Subject: Form completion: Planning Application Comments Form

refNo: 3/2021/0112

addDev: 2 St Johns Close, Read BB12 7RL

Proposed Dwelling
EXISTING SITE LAYOUT

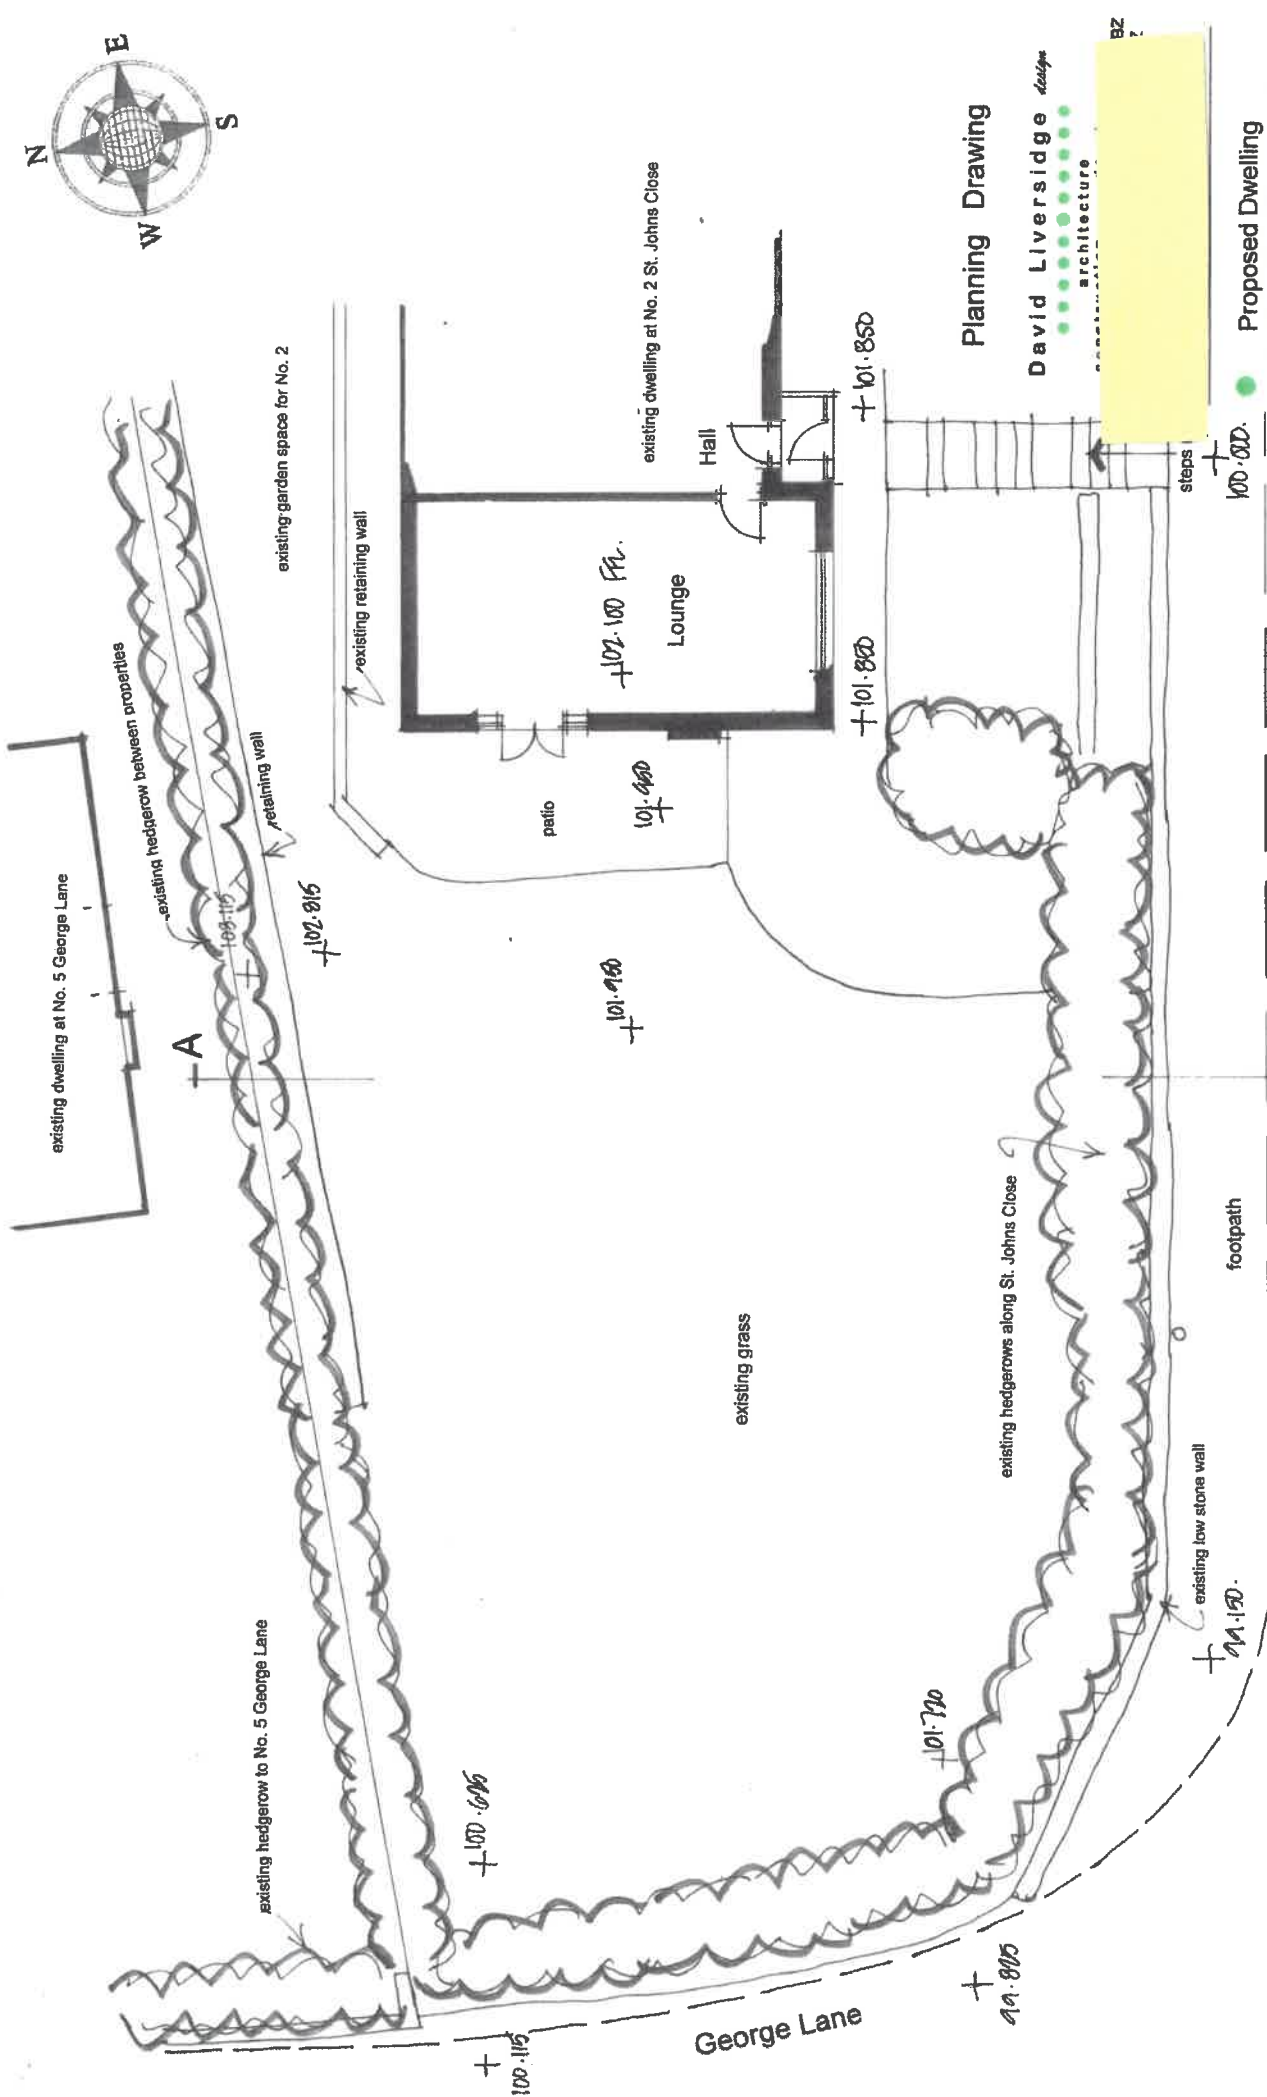
comments: I write with reference to my residence [REDACTED] which appears on each of the site plans as the closest dwelling to 2 St John Close and is sited due North from the proposed 2 storey residence and between 2 and 3 metres from the proposed building. I believe my property was built in 1963 (the same year as 2 St Johns Close). I would respectfully ask you to consider the following points associated with granting this application. 1. Effect on the local area a. What can't be easily appreciated from the plans I viewed online is the character of the buildings around the proposed 2 storey house. All residencies around the proposed site to its north, south, east and west are all bungalows or dormer bungalows. This 2 storey house is out of character in it being disproportionately high, has a 2 storey frontage forward by position to all the other dormer frontages of the other properties on the odd numbered side of George Lane and its design visually has no sympathy with the neighbouring bungalows. This planning proposal creates a disproportionate building to its neighbours creating overshadowing of the bungalows ([REDACTED] 2 St. John's close), as well as it not being in character. b. Loss of green space and openness due to building on a current garden. The proposed building would be over the entire garden of 2 St Johns Close. My feeling is that this is overdevelopment on a small plot. Creating 2 properties with a poor ratio of outside space (most easily seen in comparison with its neighbours plot sizes). c. Possibly due to the small plot size the proposed house is only 1.8m from 2 St Johns Close (a bungalow). The 2 storey building would hugely effect light, view and overshadowing on the west side of 2 St Johns (at ground level). Whilst the current occupiers

(planning applicants) obviously accept this reduction in their light and space, future occupants will have a building with reduction in light to the tune of 1 window and French doors with window, and a 2 storey building overshadowing them 1.8m away.

Proposed Dwelling  
DWELLING PLANS

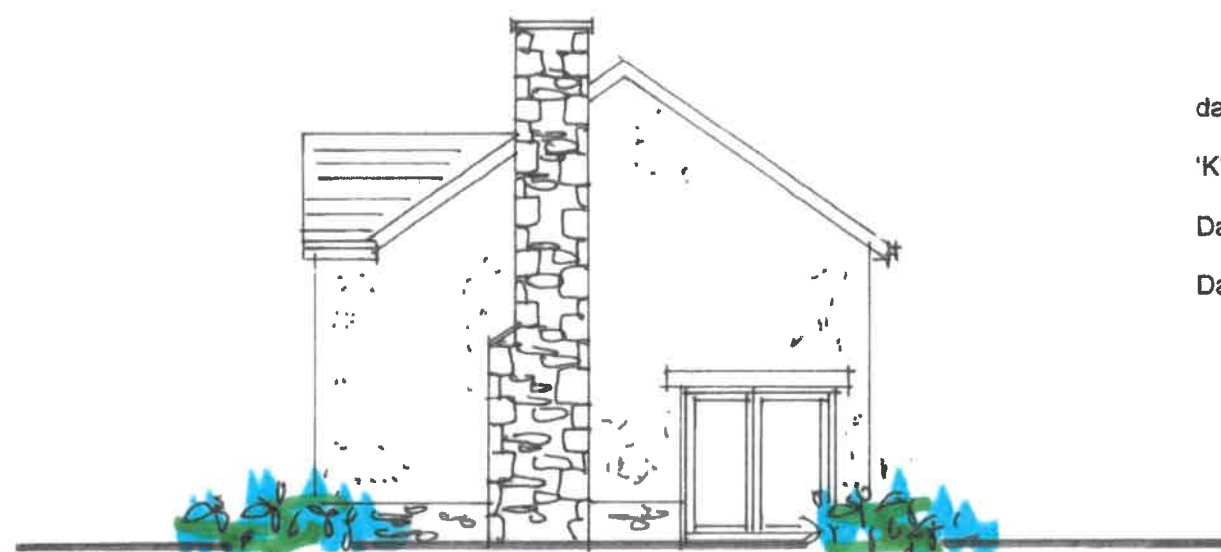
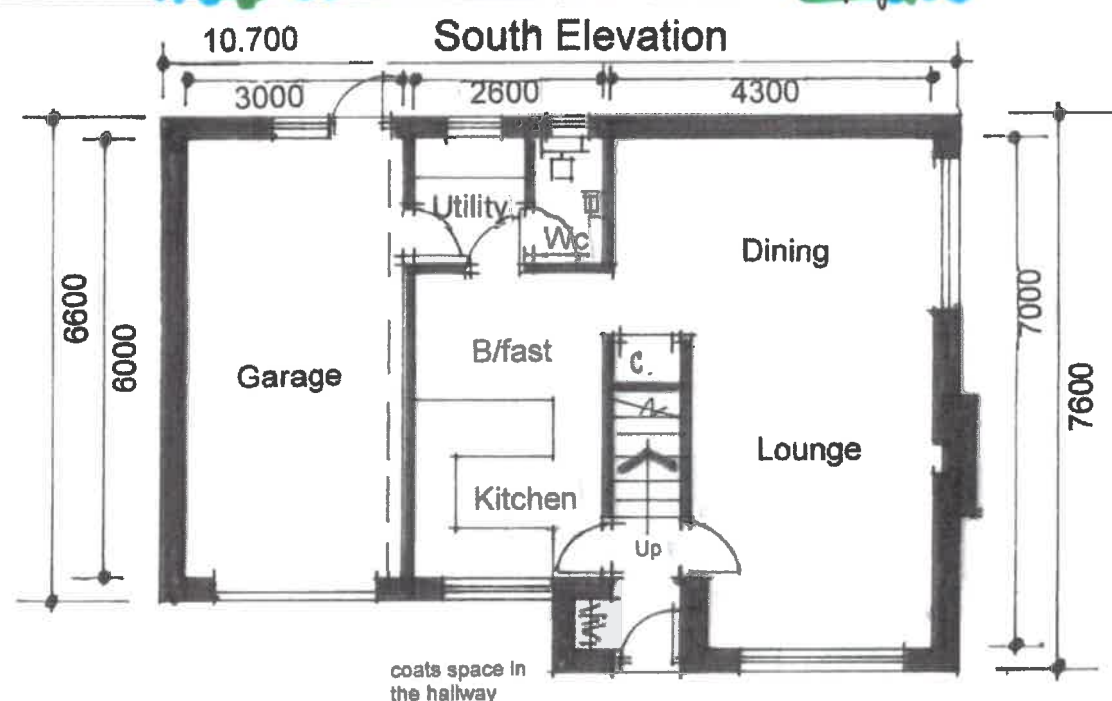
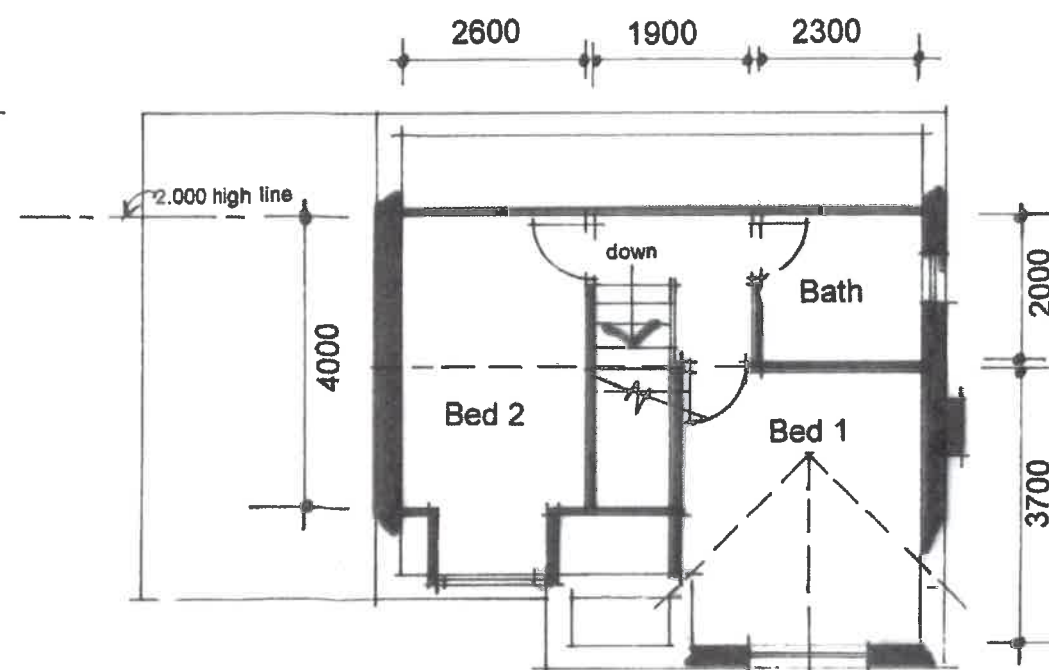
2. Loss of light and amenity a. A 2 storey building on our south side would almost totally obscure all daylight into the south side of our house and obscure the entirety of the view as a by-product, as our home has only has 1 window on the entire south side of our building. There is currently an uninterrupted sight of the whole horizon (reference point 3a). This proposed development seriously overshadows by proximity, creating an effect of enclosure and would produce zero outlook from our master bedroom affecting our "right to light" and amenity. This would certainly have an impact on our feeling of well-being due to loss of light, view and space into our Master bedroom. As far as I'm aware [REDACTED] has had an unobscured view/light since its build in 1964 b. The plans named "existing street view" indicate a hedge that already obscures the window. In fact this is not to scale and the current hedge is well below window sill level allowing currently for no obstruction of daylight at all. I only highlight this to illustrate the correct current unobscured light/view as opposed to a misrepresentation that may lead planners to feel there would be little impact by the proposed 2 storey building. c. The retaining wall to the property appears to directly abut to the building proposed. Again I highlight a plans inaccuracy (on the "Proposed Site Plan") as the distance from [REDACTED] resistance to the boundary appears visually bigger than the distance between 2 St Johns Close and the proposed building (measured at 1.8m). In fact the distance of [REDACTED] to the current boundary wall is 0.89m min to 1.3m max. This is a much smaller distance than is implied on the plans (creating a small distance between [REDACTED] and the proposed building) and whilst I appreciate that the agent drawing the plans will not have entered my property boundary to measure this I still feel this inaccuracy should be mentioned. This inaccuracy is represented once again in the lower drawing of the "proposed street view" where the distance of the [REDACTED] dwelling is only 89cm from the existing boundary wall. On the same "Proposed Site Plan" the measurement from the proposed building to the boundary line is stated as 110cm making the distance between the 2 buildings only 199cm between a bungalow and a new 2 storey high property. This would certainly create an overbearing presence by its close proximity and maximal blockage of light, view, space and solar exposure.

3. Resultant loss of income from the loss of light, and loss of Green Agenda Support a. [REDACTED] has 12 solar panels on our due south facing roof elevation at single storey (ground floor roof) level that would greatly be affected by the lack of light from a proposed 2 story building whose height would obscure parts of the day they are exposed to sun currently. The sun is due south at noon and this would be the most income generating portion of the day. This solar light reduction would be particularly aggressive during the winter months due to sun angle and aggressive in summer due to volume of sun in summer months. In Summer the sun rises to an elevation of 67 degrees dropping to a level of just 14 degrees above the horizon in winter. I'm sure you can imagine the effect of a 2 storey building due south of solar panels. The lack of light would greatly effect our ability to generate green energy and would of course have an ongoing financial impact upon our income [REDACTED] per year, for which I can supply evidence of course and constitutes a baseline for income generation that would form a historical level for future likely income). b. Equally importantly the shadowing from the proposed building would cross the entire South roof elevation of [REDACTED]. Effectively ending the ability to support the future green agenda as it would preclude our
